Lower Thames Crossing

9.117 Applicant's Comments on IP submissions at Deadline 1 to 3

DATE: October 2023
DEADLINE: 5

Planning Inspectorate Scheme Ref: TR010032
Examination Document Ref: TR010032/EXAM/9.117

Sole Street

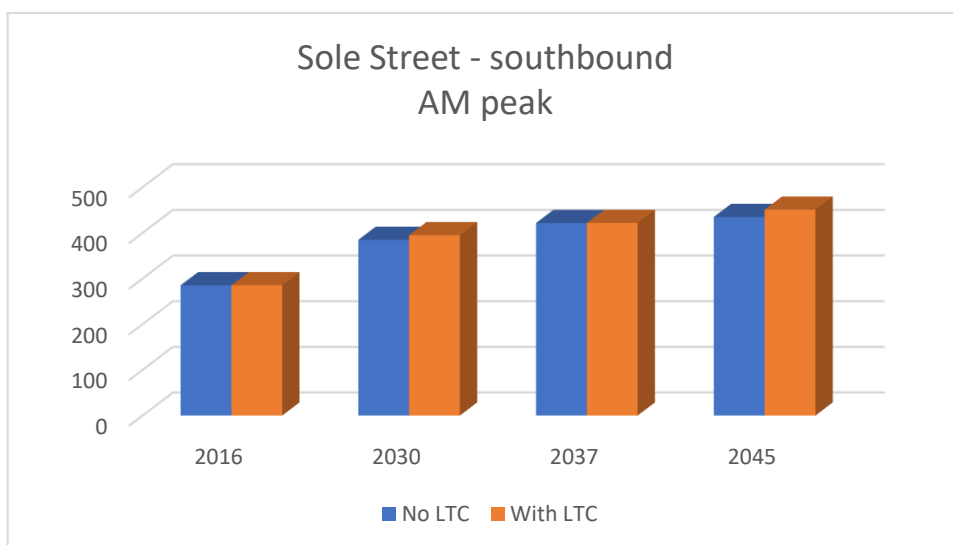
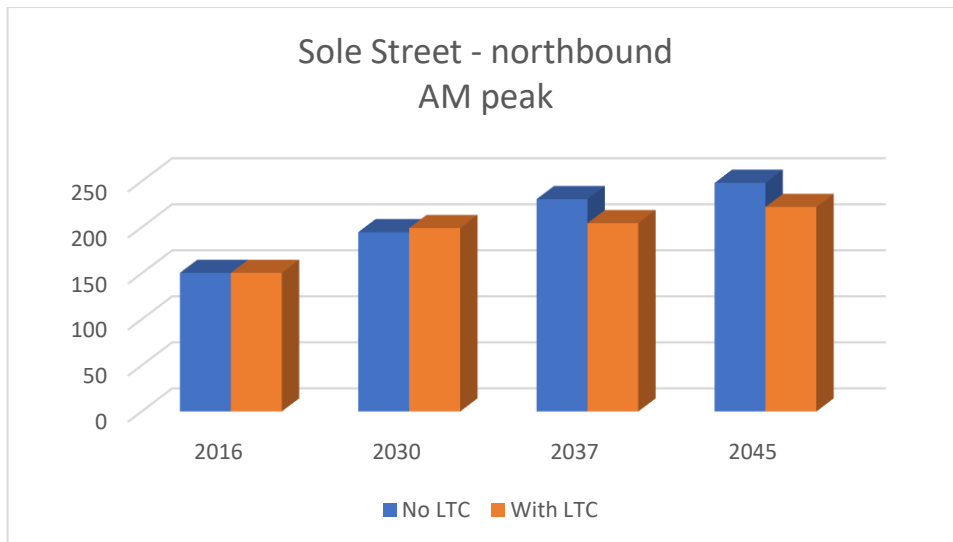
'Southbound LTC does not seem to make much difference, but northbound there is a decrease. It has not been explored in detail but at first sight the flow on Henhurst Road does not seem to sit well with the flows on Sole Street and The Street.'

2.1.4 In response to this comment, the Applicant has reviewed the Lower Thames Area Model (LTAM) SATURN cordon model that was provided to Gravesham Borough Council. It shows that the decrease on Sole Street and increase in Henhurst Road which '*does not seem to sit well*' is due to a small re-routing change in the centroid connectors used from the local traffic zone that loads local traffic from Sole Street and Cobham onto the network. This effect would not be apparent from the GIS shapefiles but is shown in the LTAM SATURN model. The number of vehicles involved in the re-routing is very low. As shown in the extract from LTAM in Plate 2.1 below, with the Project, 29 trips switch from loading onto the network at Sole Street to go northbound and instead are loaded onto the network on The Street and go northbound along Henhurst Road.
